**Consultation Response from KC,
Trees**
2025/90889 Former Combs Hostel, Hall Lane, Thornhill, Dewsbury, WF12 0PL
Demolition of existing hostel and erection of residential development comprising 34 dwellings
Date Responded: 18/03/2026
Responding Officer: Hazel Irving
Responding Ref: n/a

Photo 2: T8 from northeast.

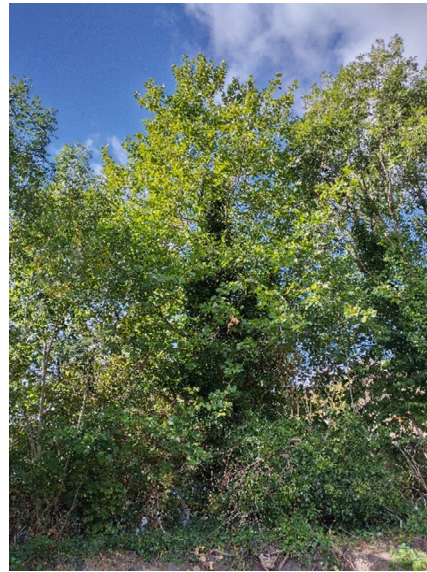
One example, T8 (London Plane) at its current immature size would have to be reduced to facilitate the development of the proposals, as a building is proposed at the edge of the current canopy-line. However, London Plane can grow to more than double this size. For trees to be retained in the long-term within a development the design must allow adequate space between proposed structures and the ultimate size existing trees, when fully mature.

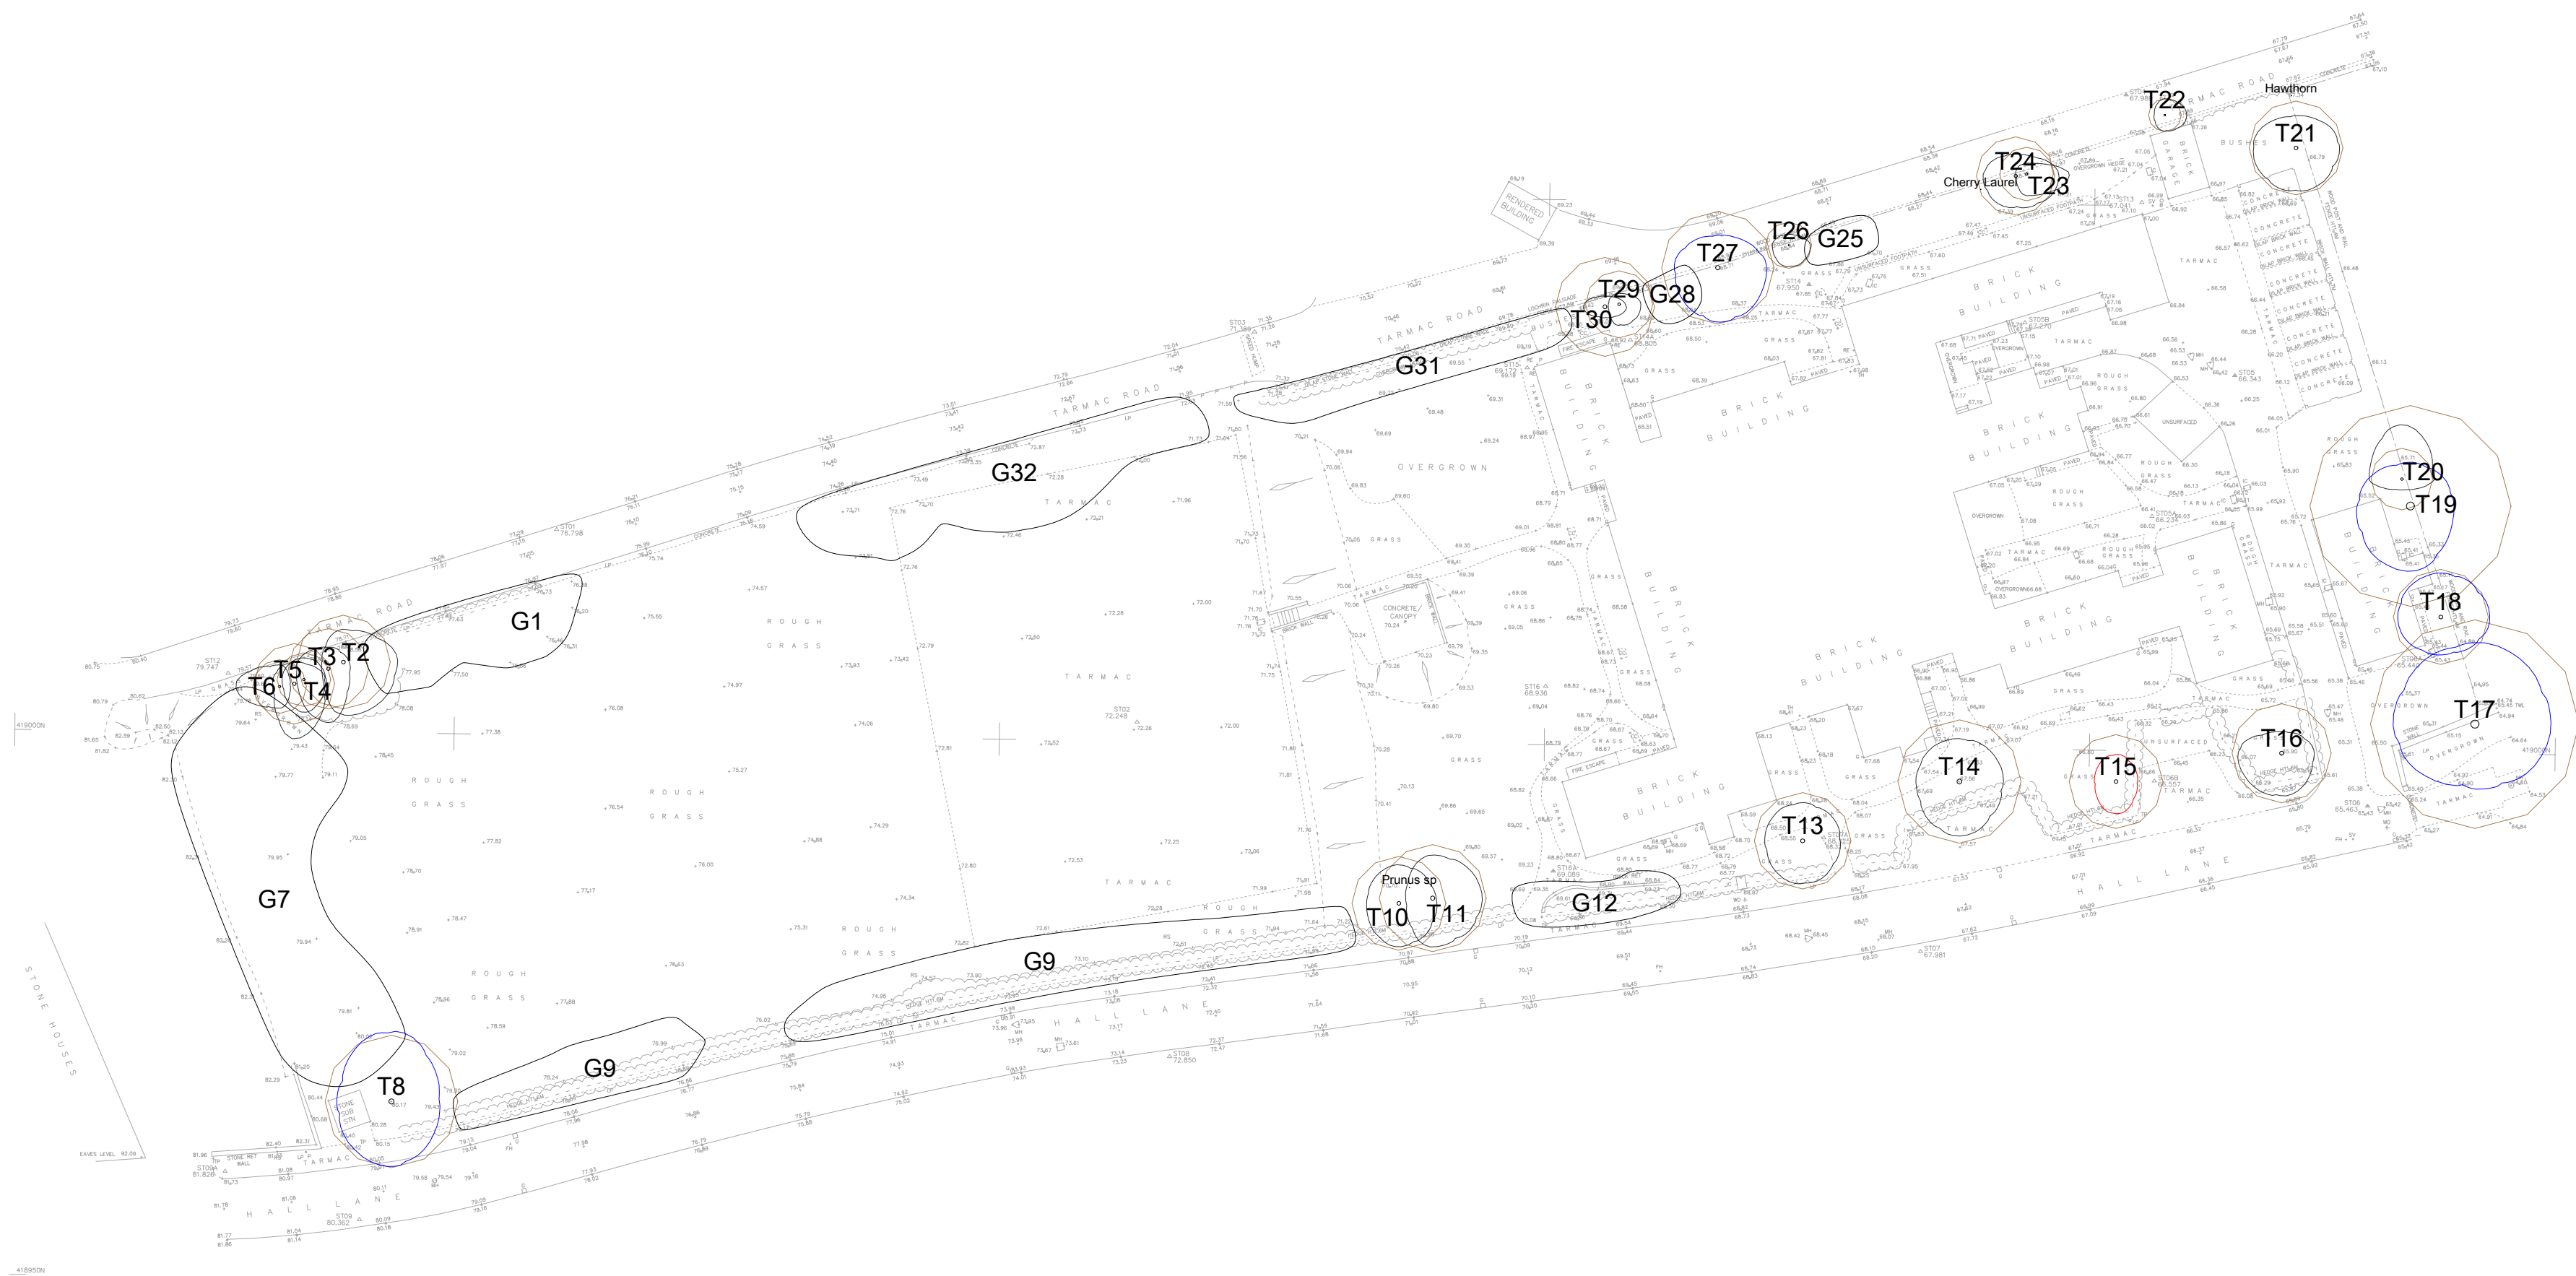
This spacing issue will also impact G7, T6, T5, T4, T3, T2, G1 all of which have development encroaching their canopy lines. Additionally tree group G32, comprising of Ash and Sycamore currently stands on the Northern boundary and would need to be partially removed to facilitate the development of two dwellings. Lastly, T30, T29, G28, T27 and T26, also on the northern boundary are in proximity to proposed dwellings and will foreseeably shade the rear gardens and require regular pruning works to keep them from growing southward towards the new structures.
